Your Ref: OWPC16794
Our Ref: BR/194/17/PL 30-06-2017
Please ask for:
Richard Temple

Demolition of the existing Foreshore office & decommissioning of existing underground toilets. New purpose built unisex toilet block including urinals, baby changing facilities & accessible WC, plus a separate beach office with public information point & first aid facilities. All located on the existing seafront promenade.

Promenade Opposite Walton Avenue The Esplanade Bognor Regis

Thank you for your internet representation made on 3rd January 2018 which has been recorded as '**an objection**' with the comments as follows:

DRAWING
Proposed Toilet Elevations

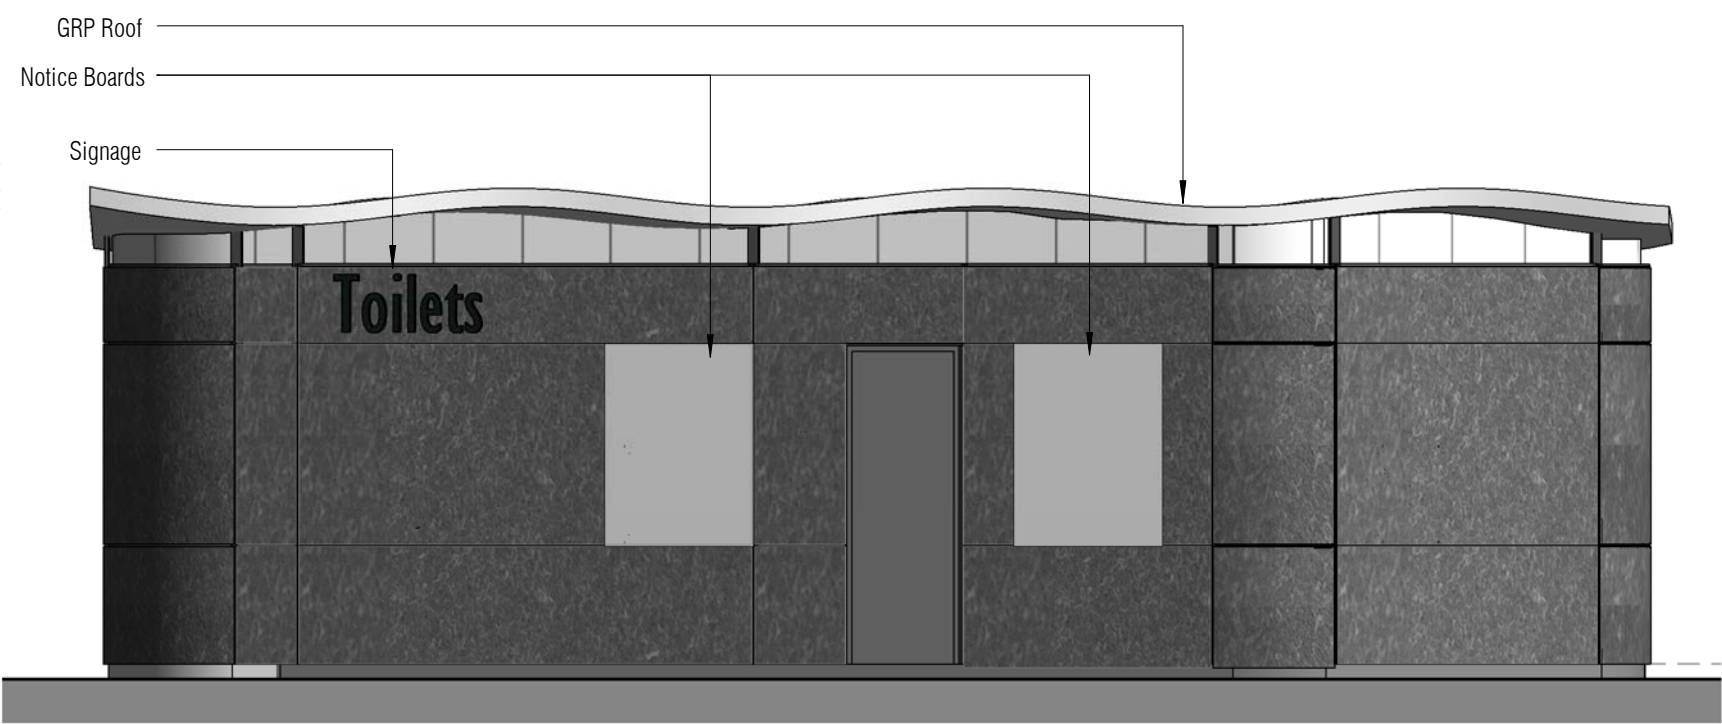
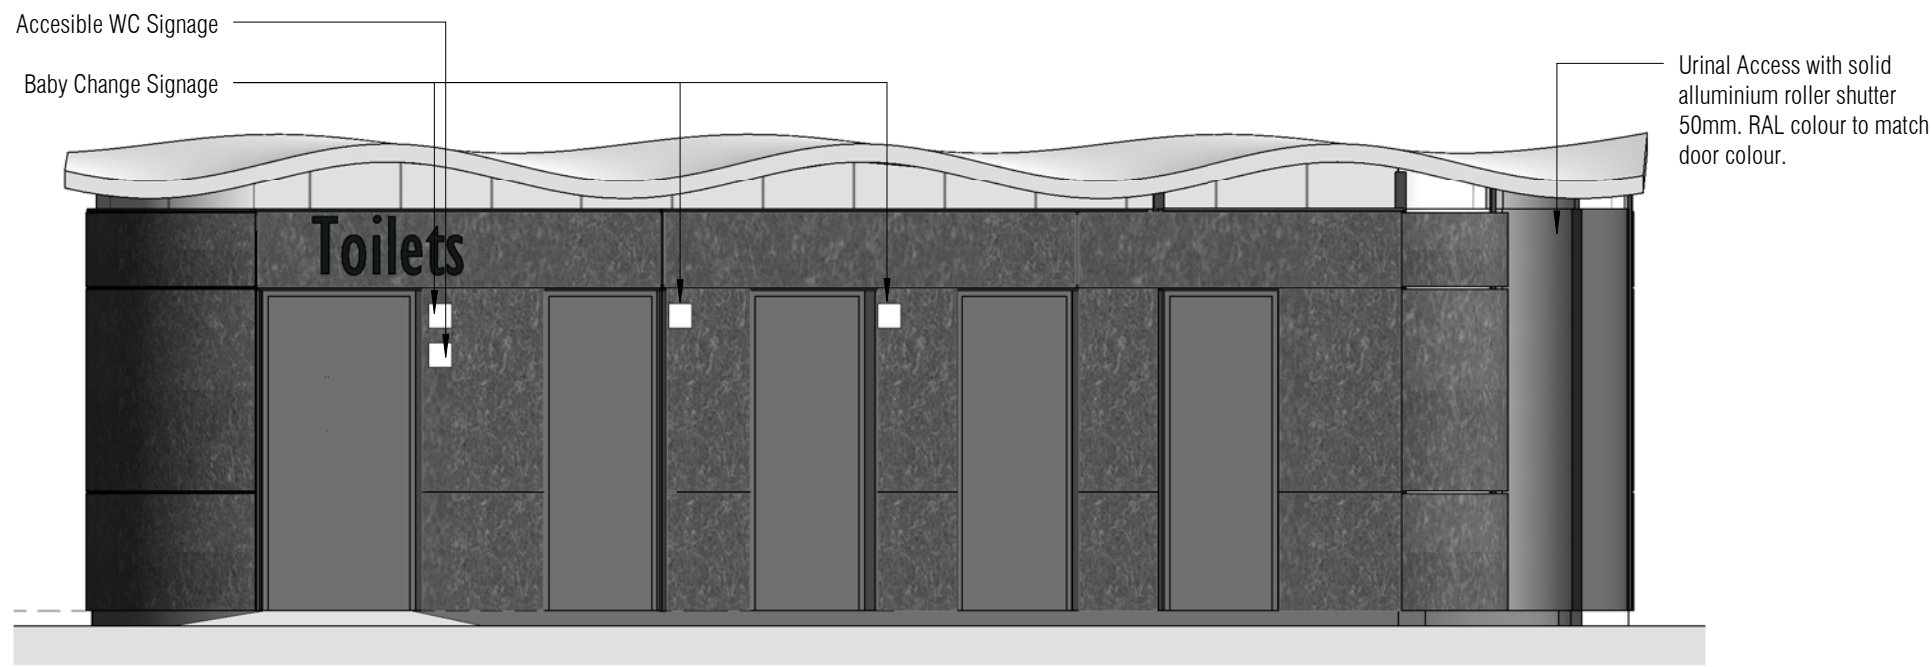
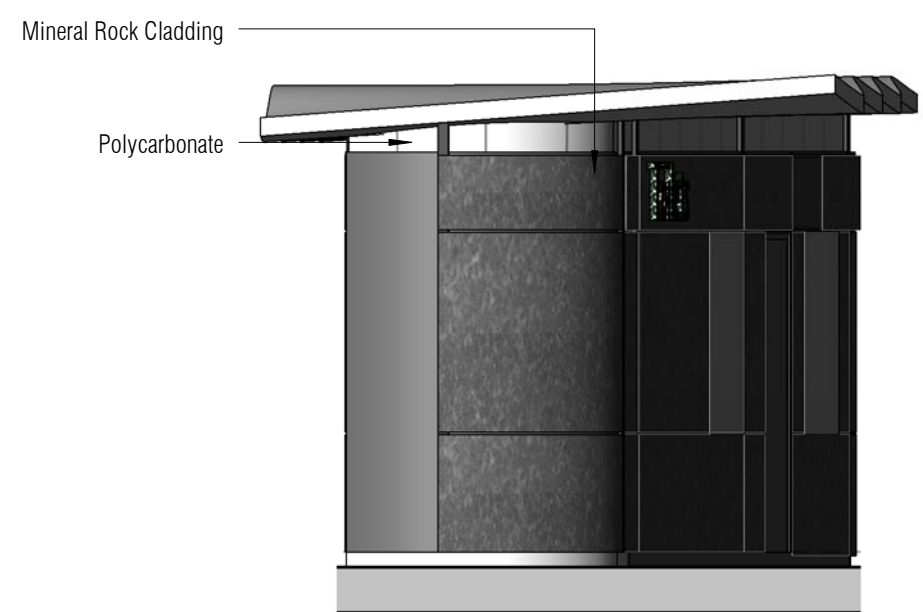
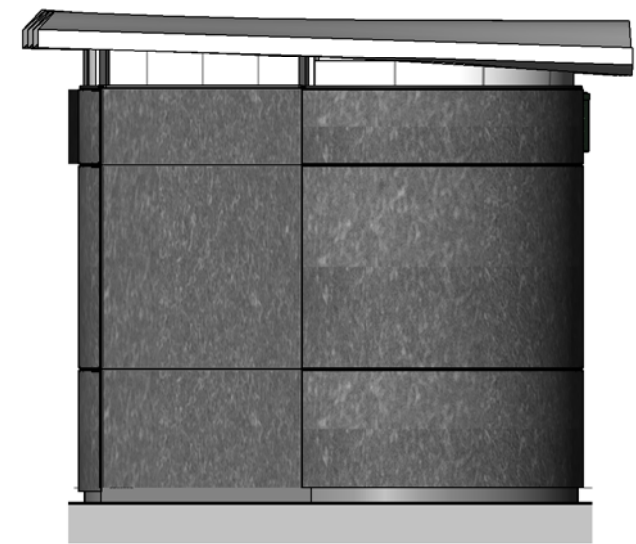
I object the large labels of TOILETS written on the back and sides of the proposed build these toilets are for beach side users not the main traffic area so it is unnecessary to display this and I don't wish to look out of my windows and see the written TOILETS sign this is not needed and is in bad taste please review these unwanted signs and remember these are for beach and promenade users not for the traffic to come to a stand still with coaches and lorries pulling up . Thanking you
